Development Facilitation Team (DFT) – Review Comments

Project No: PR-2024-009956 Date: 3/19/2025 Agenda Item: #5 Zone Atlas Page: M-9

Request: Proposed site improvements for a new tenant building with a Taco Bell quick-service restaurant with accessory drive-thru on the Endcap.

Application For: SI-2024-01475 – SITE PLAN DFT

HEET NO.  
L101

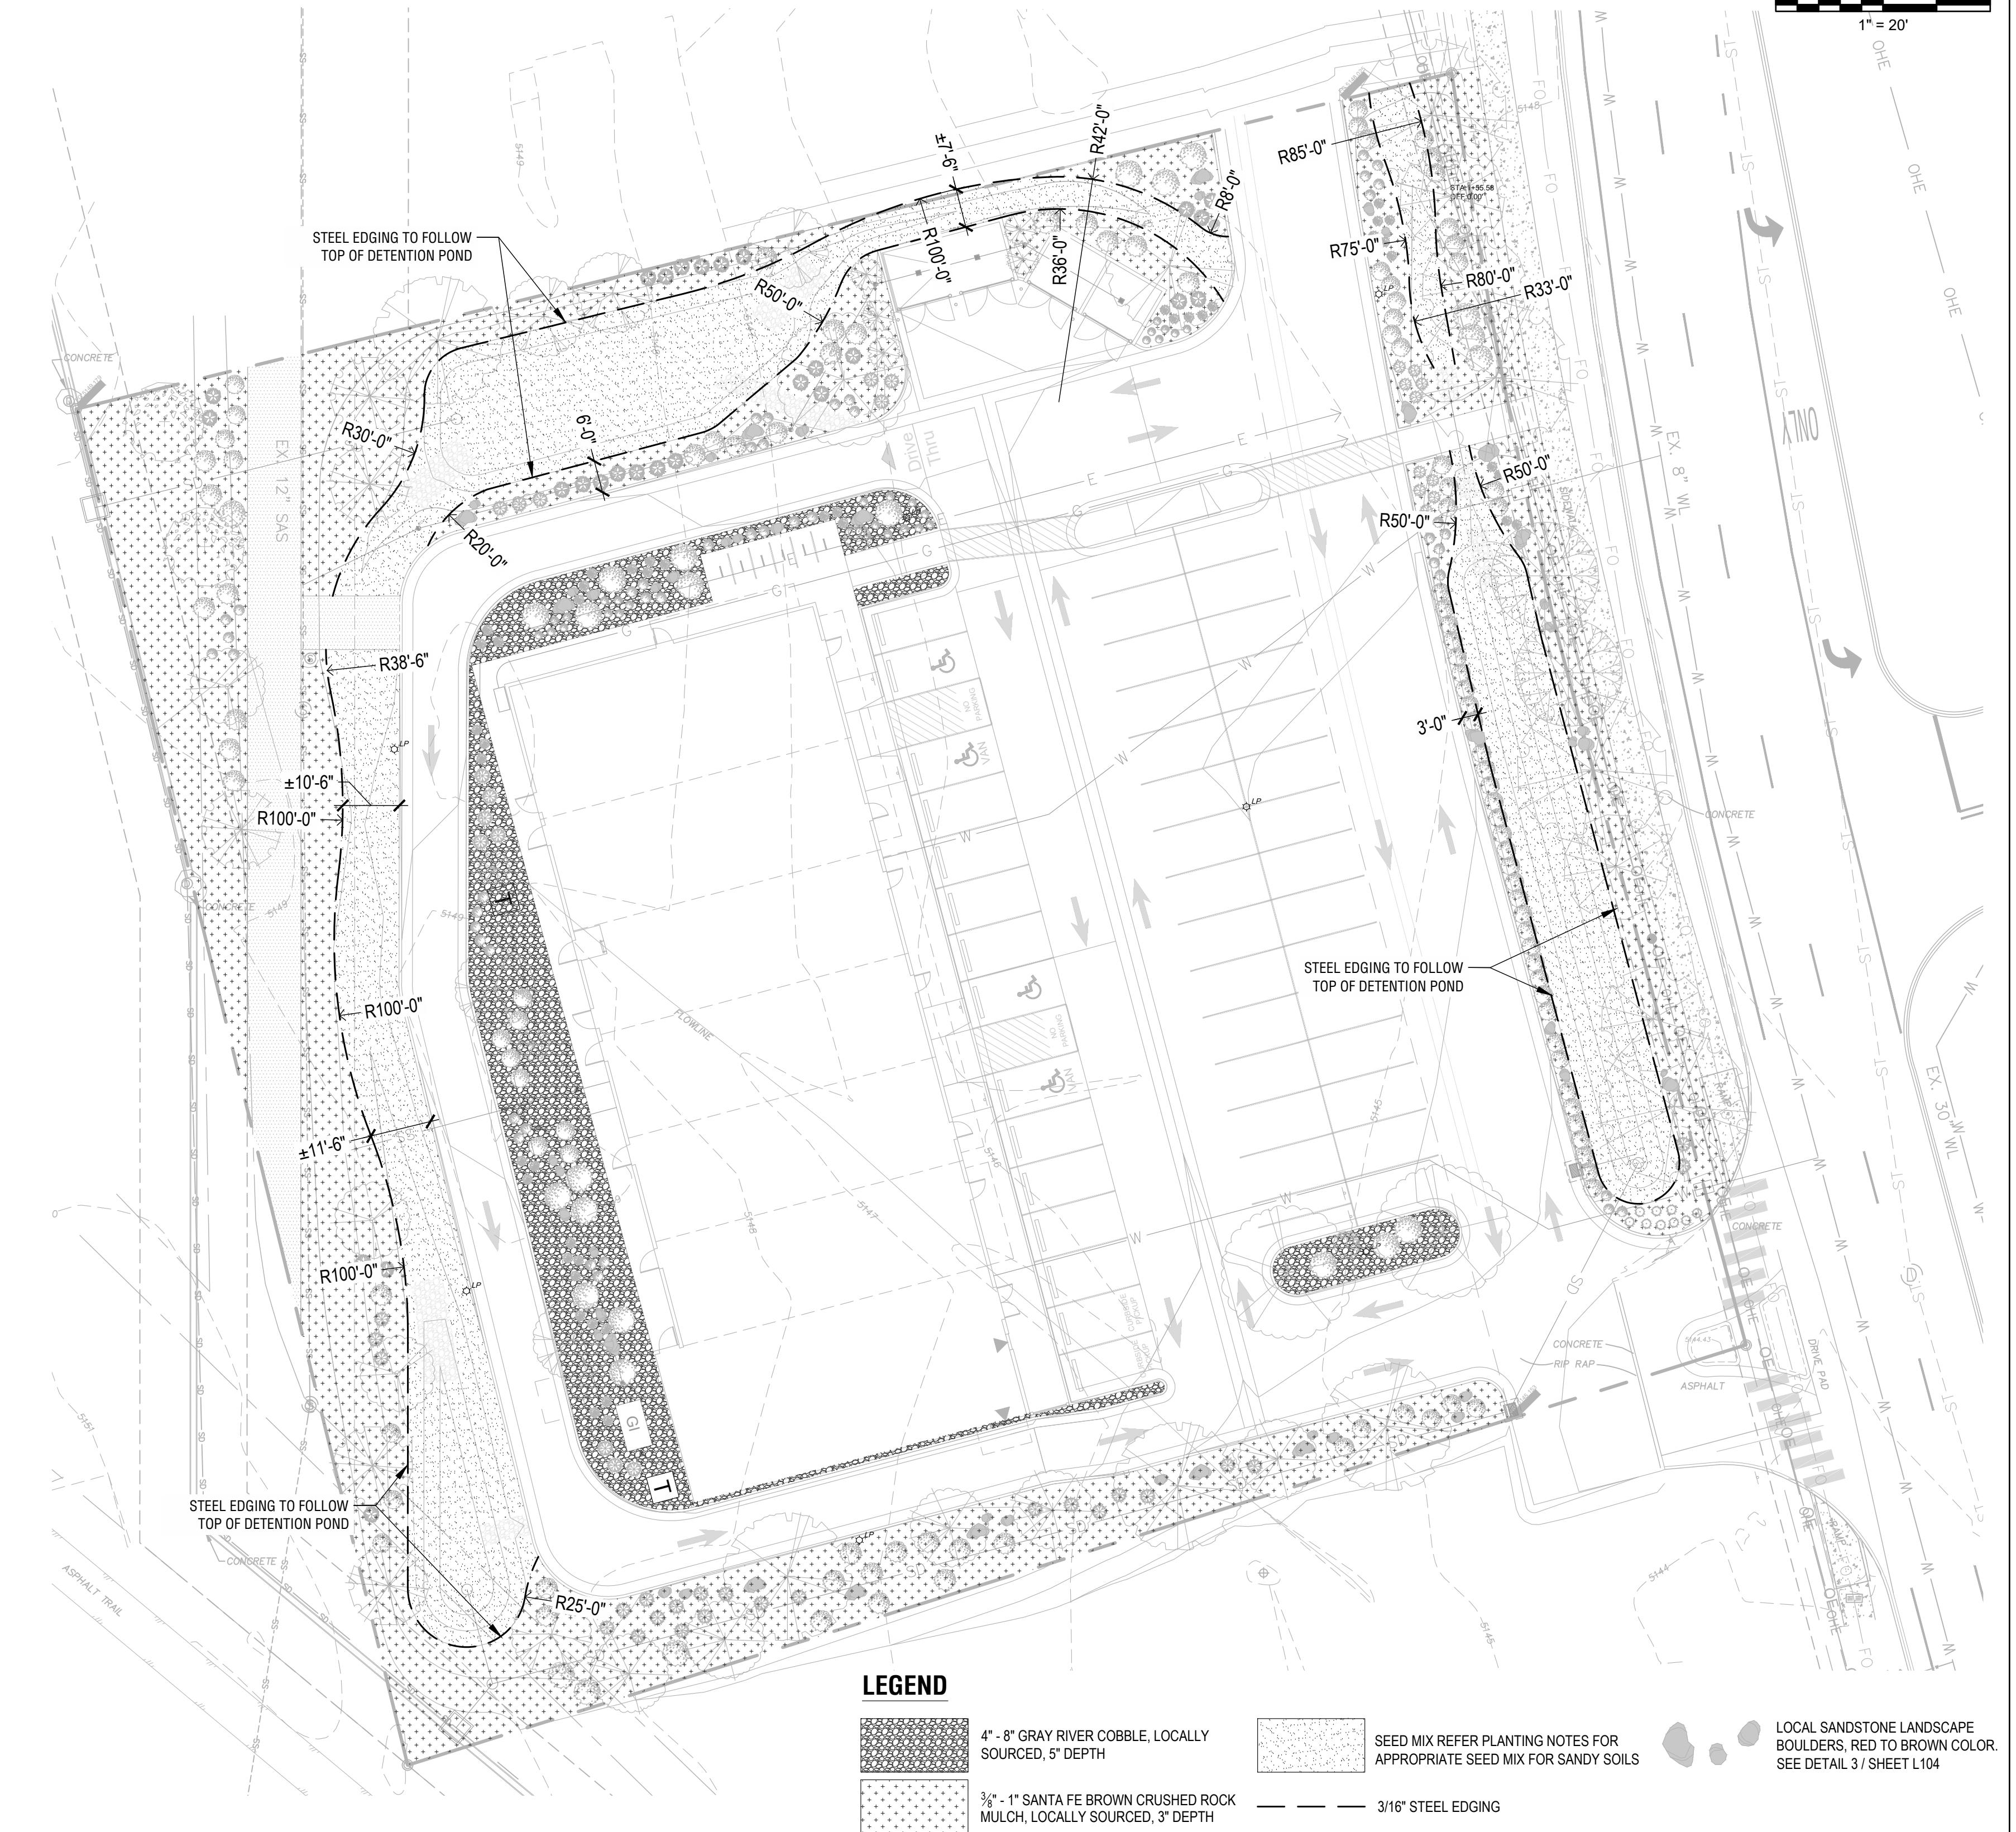
- Per 5-6(C)(10)(f), trees shall not be planted near existing or proposed street light poles. [confirm compliance with this code. Locations of light poles to be shown on the plan.](#)
[Locations of light poles shown, 15' offset shown, trees planted at least 15' away](#)

- Street Trees: Trees are generally required along street frontages every 25 feet on center unless specified otherwise in Part 6-6-2 of ROA 1994 (Street Trees). Along street frontages where street trees are required, trees that are planted within 20 feet of the back of curb of the abutting street may fulfill this requirement. Consider alternating the street trees to avoid any future spread of disease among same species. Please note the previous comment on this page.
[Compliant](#)

1 TYPICAL TREE PLANTING  
NTS

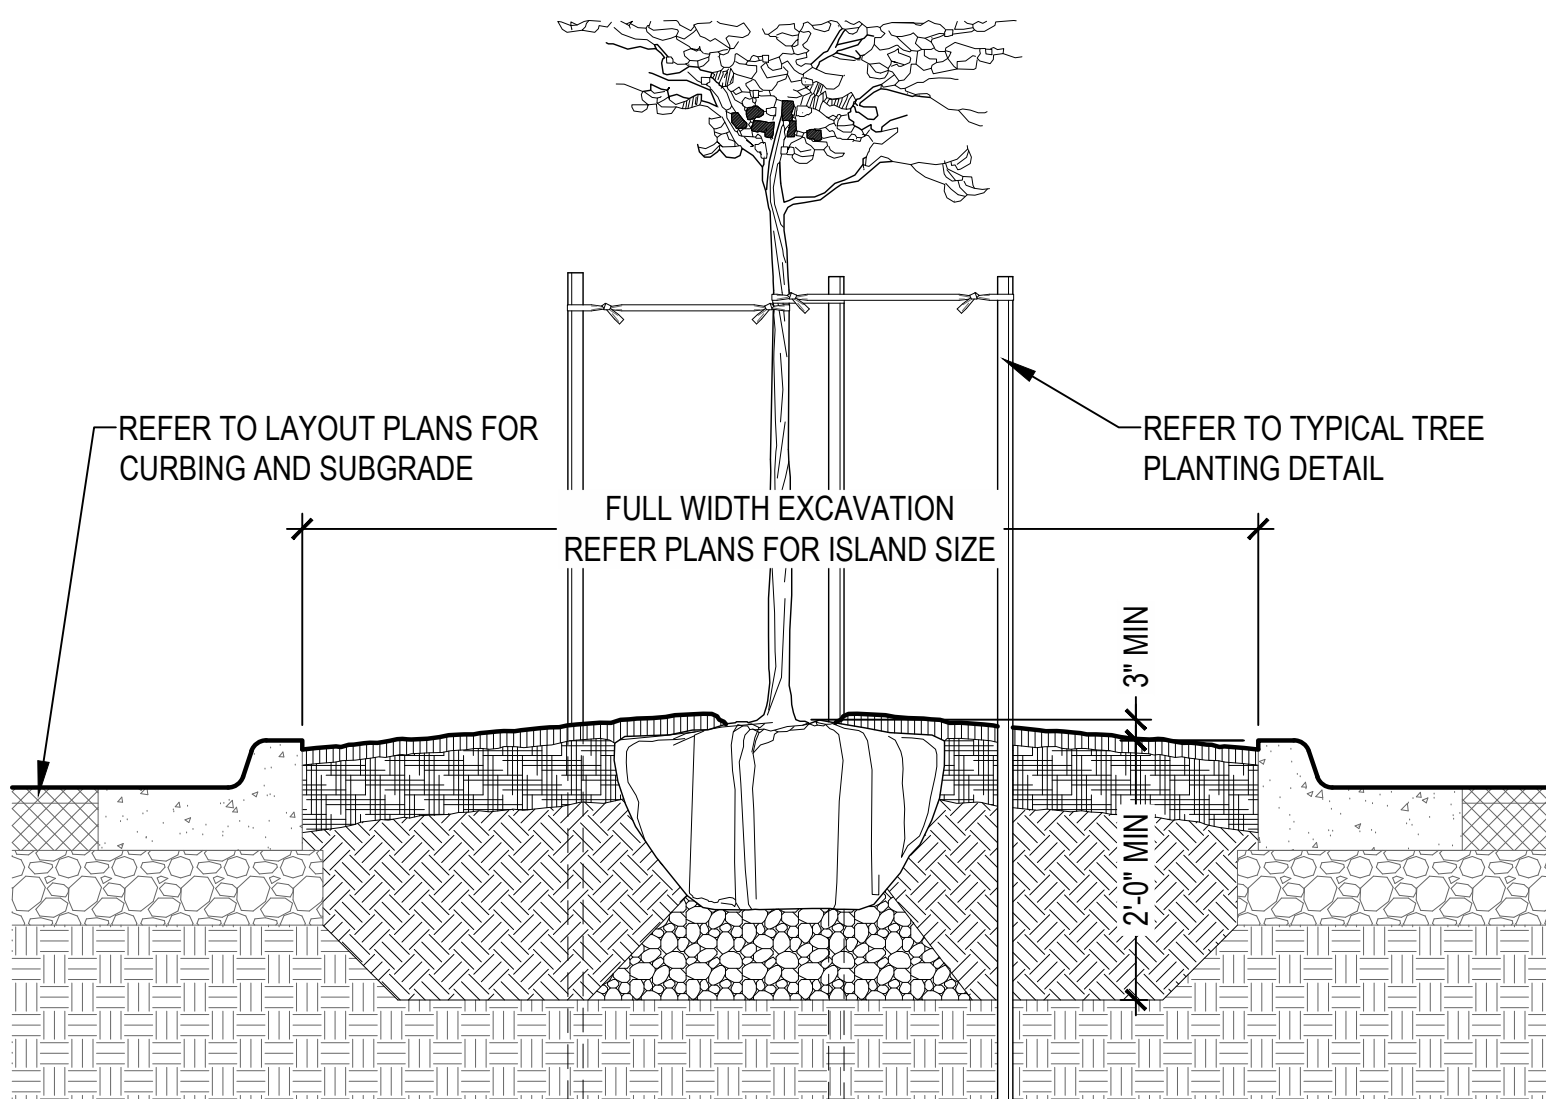
- Per 5-6(C)(5)(e) Organic mulch is required as ground cover under trees within a 5-foot radius around the tree trunk, but not directly against the trunk. In these areas, weed barrier fabric is prohibited. [The 5' radius organic mulch must be shown and called out on all tree planting details.](#) Please see the figure below from the IDO 5-6(C)(5)(e) for more clarification.

[Organic mulch noted in notes and details](#)
